The Secretary
NSW Planning, Industry & Environment

10 December 2019

I refer to the Department's below email of 8 November 2019 regarding State Significant Development SSD-9476 at Corner Commissioners Drive and Elkhorn Street, Denham Court (Lot 9001 DP 1206596) for 'New East Leppington Primary School. Construction of a new public primary school for up to 1,000 students from Kindergarten to Year 6'. Submissions need to be made to the Department by 11 December 2019.

Figure 41: Fire hydrant booster and building locations

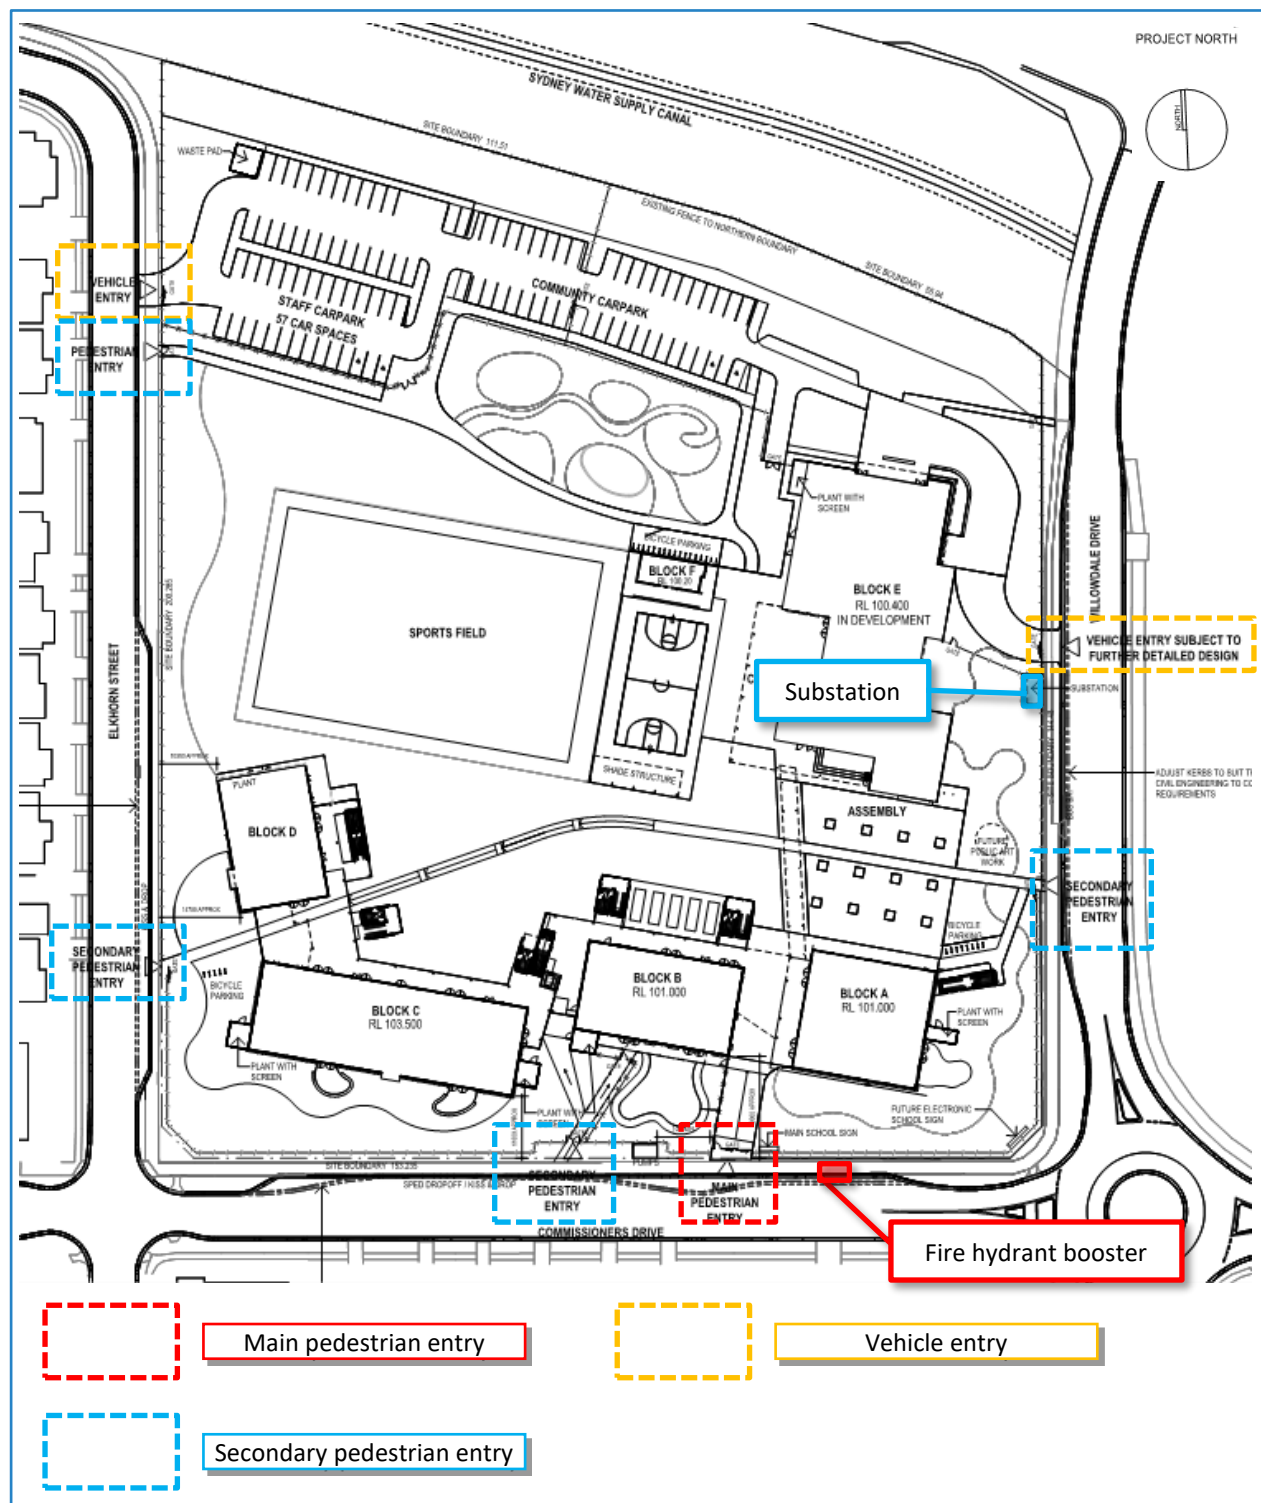
As shown in the following extract of the Proposed Architectural Plans provision has been made for a padmount substation to the Willowdale Drive frontage of the site.

It is envisaged that a 1000 kVA padmount substation proposed to be located along the Willowdale Drive frontage will be connected to existing 11 kV high voltage underground feeder cable between existing Padmount Substations No. s 33882 and 34912 (shown in the following plan) which shares the trench with another high voltage feeder cable on the same side of the street.

From Endeavour Energy's perspective the fact that provision is being made for the substation is a positive. Endeavour Energy's general requirements is for a padmount substation to be at ground level and have direct access from a public street (unless provided with a suitable easement for right of access). It must be protected (including any associated cabling) by an easement and associated restrictions benefiting and gifted to Endeavour Energy as outlined in the attached copy of Endeavour Energy's Mains Design Instruction MDI 0044 'Easements and Property Tenure Rights'.

The padmount substation easement has a minimum size of 2.75 x 5.5 metres and must also have the additional restrictions for fire rating (which usually extends 3 metres horizontally from the base of the substation footing, and 6 metres vertically from the same point and also has regard to any structures etc. attached to the building that may spread a fire) and possibly swimming pools and spas (which extends five meters from the easement but in this instance does not appear to be applicable).

Generally it is the Level 3 Accredited Service Provider's (ASP) responsibility (engaged by the developer) to make sure that the substation location and design complies with Endeavour Energy's standards the suitability of access, safety clearances, fire ratings, flooding etc. As a condition of the Development Application consent the Department should request the submission of documentary evidence from Endeavour Energy confirming that satisfactory arrangements have been made for the connection of electricity and the design requirements for the substation, prior to the release of the Construction Certificate / commencement of works.
